**Consultation Response from Alan Smith,
KC Waste Strategy (Refuse & Recycling)**

2026/90857 HSBC, 2, Cloth Hall Street, Huddersfield, HD1 2EG

Conversion and extension of sixth floor plant room to form communal space, office and plant room area including re-cladding and new window openings, external alterations including new access door openings and replacement windows (in association with previously-approved change of use of floors 1-5 inclusive to 28 flats/studios and change of use of part of ground floor to provide associated facilities for the flats/studios, including refuse store, approved pursuant to application 2025/91221) (within a Conservation Area)

Date Responded: 09/06/2026

client	HD CENTRAL		
project	DEVELOPMENT OF FORMER HSBC BANK 2 CLOTH HALL STREET HUDDERSFIELD HD1 2EG		
drawing	PROPOSED GROUND FLOOR PLAN		
revision	notes	date	drawn
E	ACCESS DOORS AMENDED AND INTERNAL REVISION	03.26	PB
scale :	1:50 AT A1	03.25	PB
project no.	drawing no.	revision	
2412	10	E

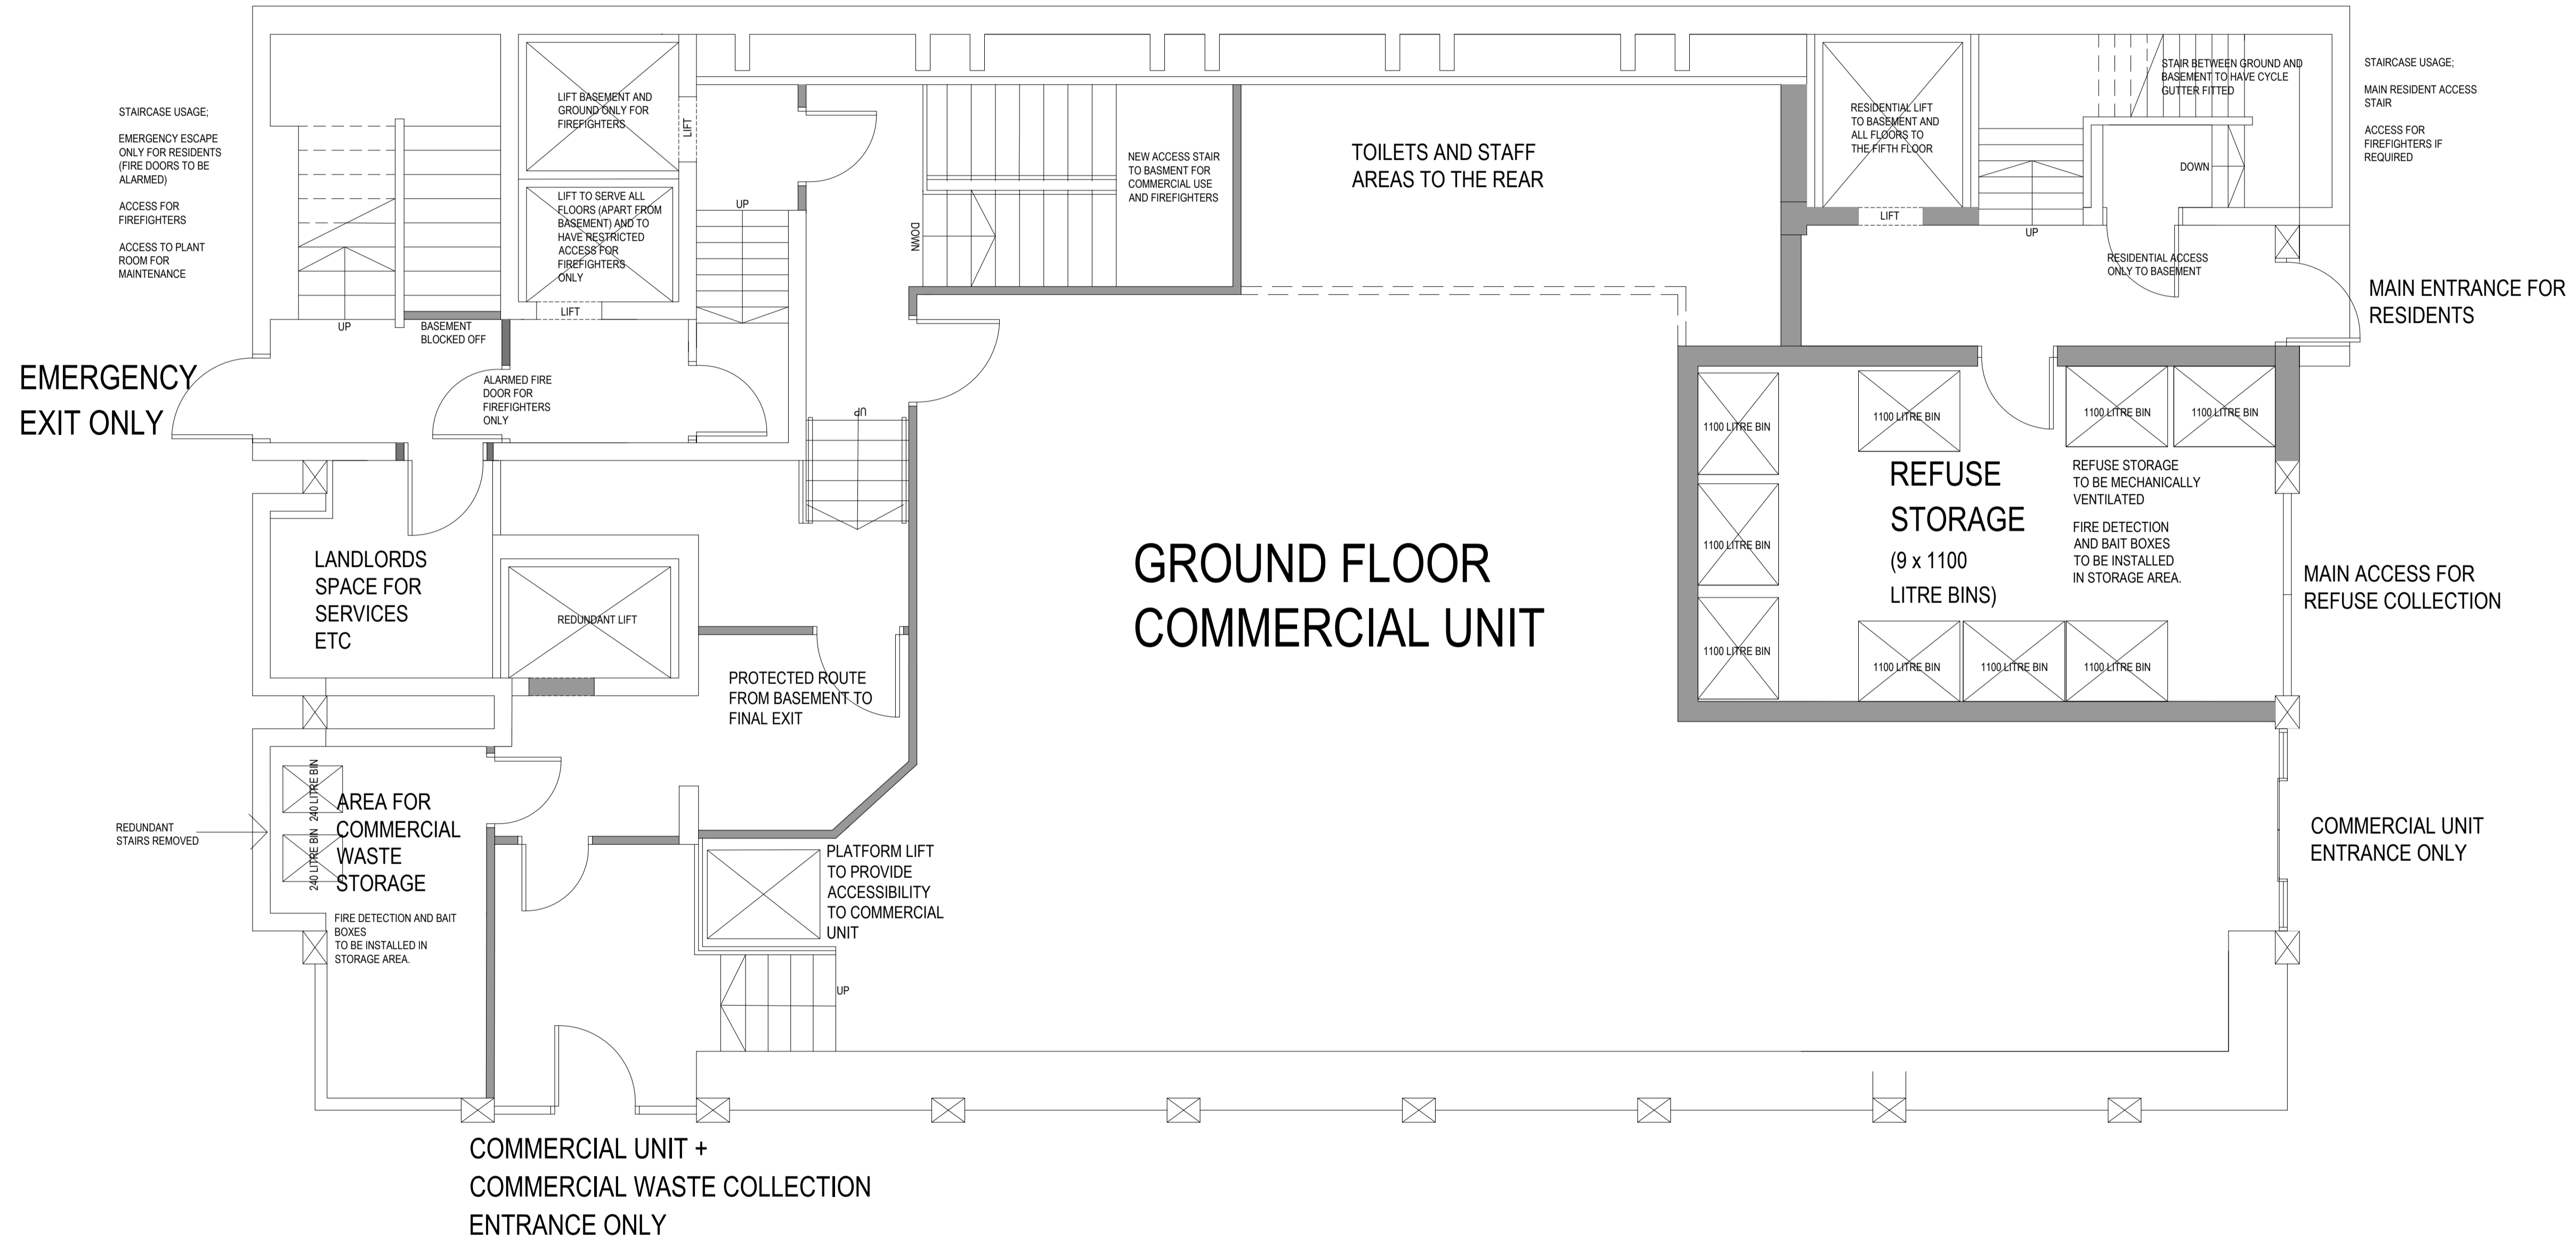
It is noted that the number of dwellings is to go back to 28. In this case 9 x 1,100 wheeled bins will be needed as previously agreed and shown on the drawings.

The location of the proposed bin store has changed but my comments from my response dated 19/06/2025 still apply to the proposed bin store area for this application as well as the proposed conditions.
